Ribble Valley Borough Council
Housing & Development Control

Your ref: 3/2023/0926
Our ref: D3.2023.0926
Date: 5th January 2024

Application no: **3/2023/0926**

Proposal: **Construction of two storey extension to side and rear, including conversion of existing garage.**

Site Plan - 1:200

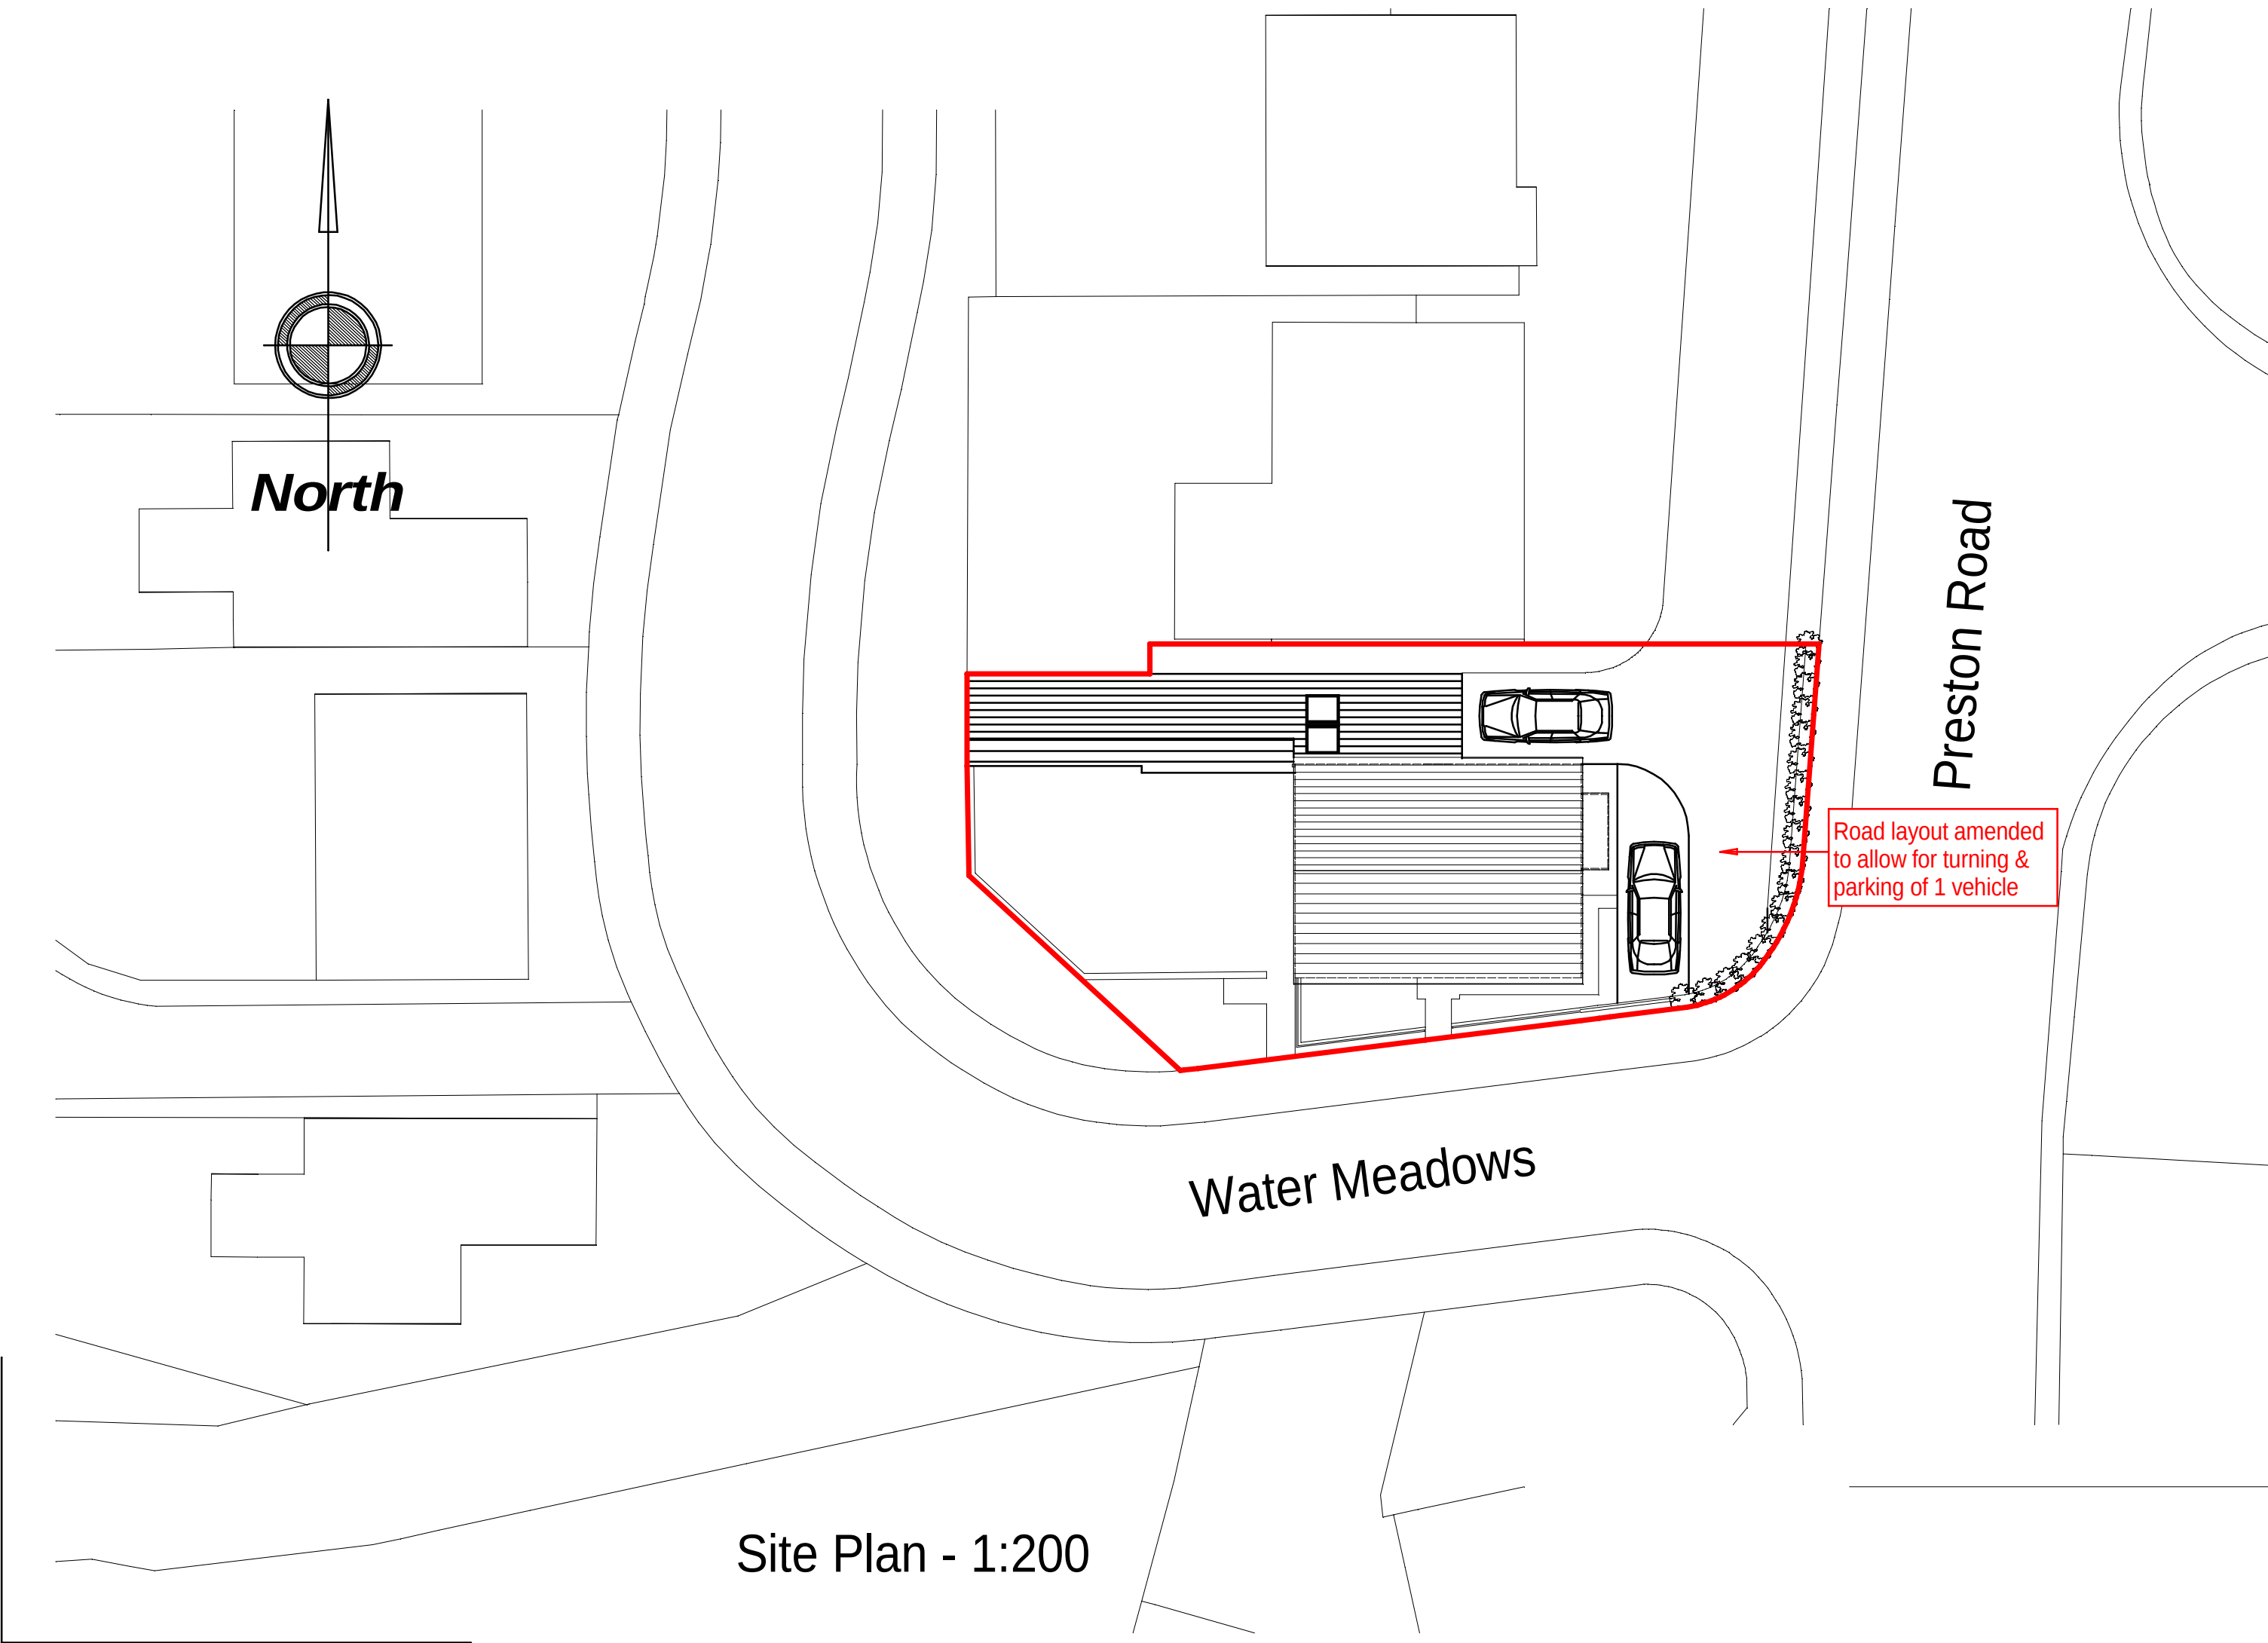
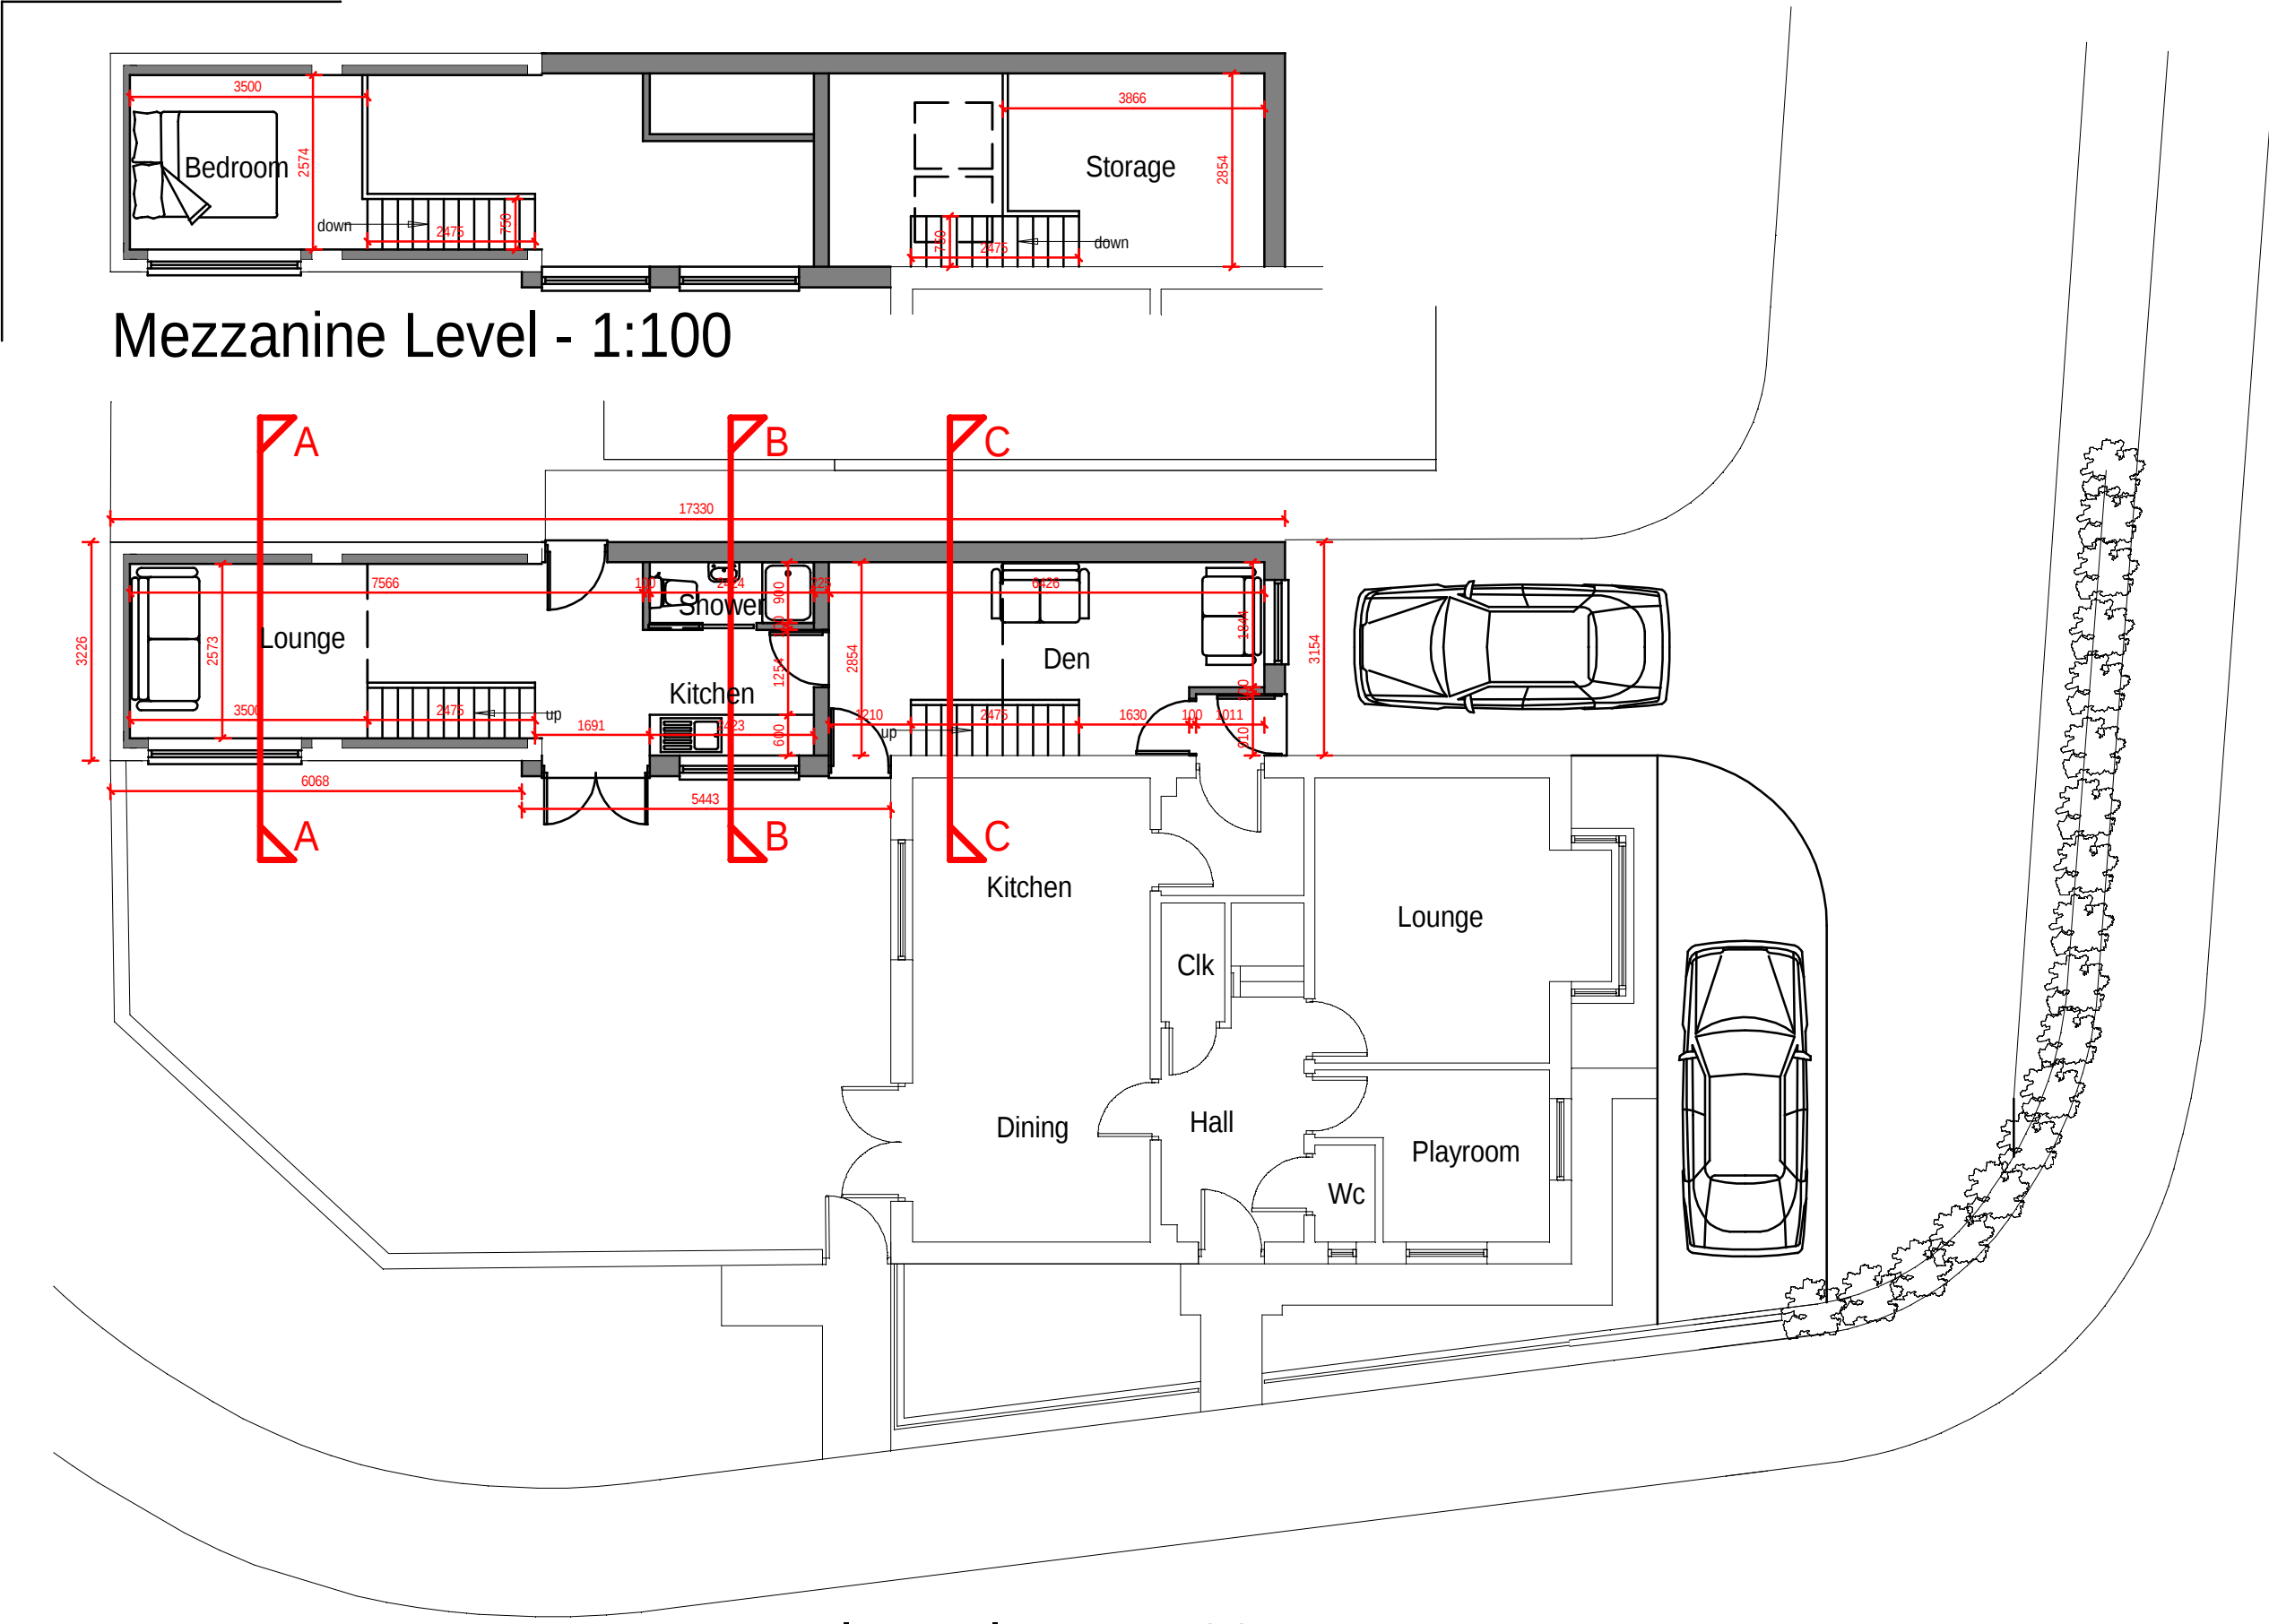
The LHA have reviewed drawing number NMB/WM/002 Rev A titled "Proposed Extension and Alterations" and are aware that the parking arrangements at the site will change following the proposal. While the number of bedrooms at the site will remain as a 4+ bed dwelling, the extension to the dwelling will lead to a loss of one car parking space, with 3 spaces currently being provided on the existing driveway.

Following the proposal, one car parking space will be provided on the driveway, while the other space will be in the turning area for the shared access track which serves three other dwellings. This track is taken from the main spine road of the residential estate called Water Meadows.

Providing a car parking space within the turning area for the shared access track is unacceptable. This is because a car parked within the area will likely obstruct the use of the turning head for other vehicles using the access track including delivery and emergency vehicles when they are servicing the property and neighbouring properties. This would lead to these vehicles being unable to turn within the site and enter and leave in a forward gear, causing them to have to reverse for a considerable distance before engaging in a forward gear. This is in a location which has no segregated pedestrian facilities and one which serves each dwellings parking areas. Therefore, the LHA are concerned that the proposal will compromise highway safety given the distance a vehicle will have to reverse and there being numerous potential conflict points.

The LHA understands that the turning area of the shared access track is located within the dwellings red line boundary. However, the LHA are aware by reviewing the supporting information for application reference 3/2021/0190 that the other dwellings located along the shared access track have a right to use the turning area. The right of the other dwellings to access the turning area was established as part of the original planning

Even if information was submitted which showed the use of the turning area was not compromised there would still be a shortfall of one space given the number of bedrooms at the dwelling. Therefore, the LHA are concerned that the shortfall in parking at the site would be accommodated in the turning area of the shared access track. This would be unacceptable and would be to the detriment of highway safety for the reasons highlighted above.

The LHA acknowledge that the turning area for the shared access track has not been designed adequately as vehicles will have to use the dwellings driveway to exit the site in a forward gear. However, the proposal will make the existing situation worse with the turning area becoming a car parking area for the dwelling. This would be to the detriment of highway safety with there being no facilities for vehicles using the access track to turn and exit the area in a forward gear, leading to vehicles having to reverse for a considerable distance before having adequate space to manoeuvre and engage in a forward gear. This is in a location which has no segregated pedestrian facilities and one which has numerous site frontages that serve each dwellings parking areas. Therefore, the LHA are concerned that the proposal will compromise highway safety which is contrary to paragraph 115 of the National Planning Policy Framework (2023).
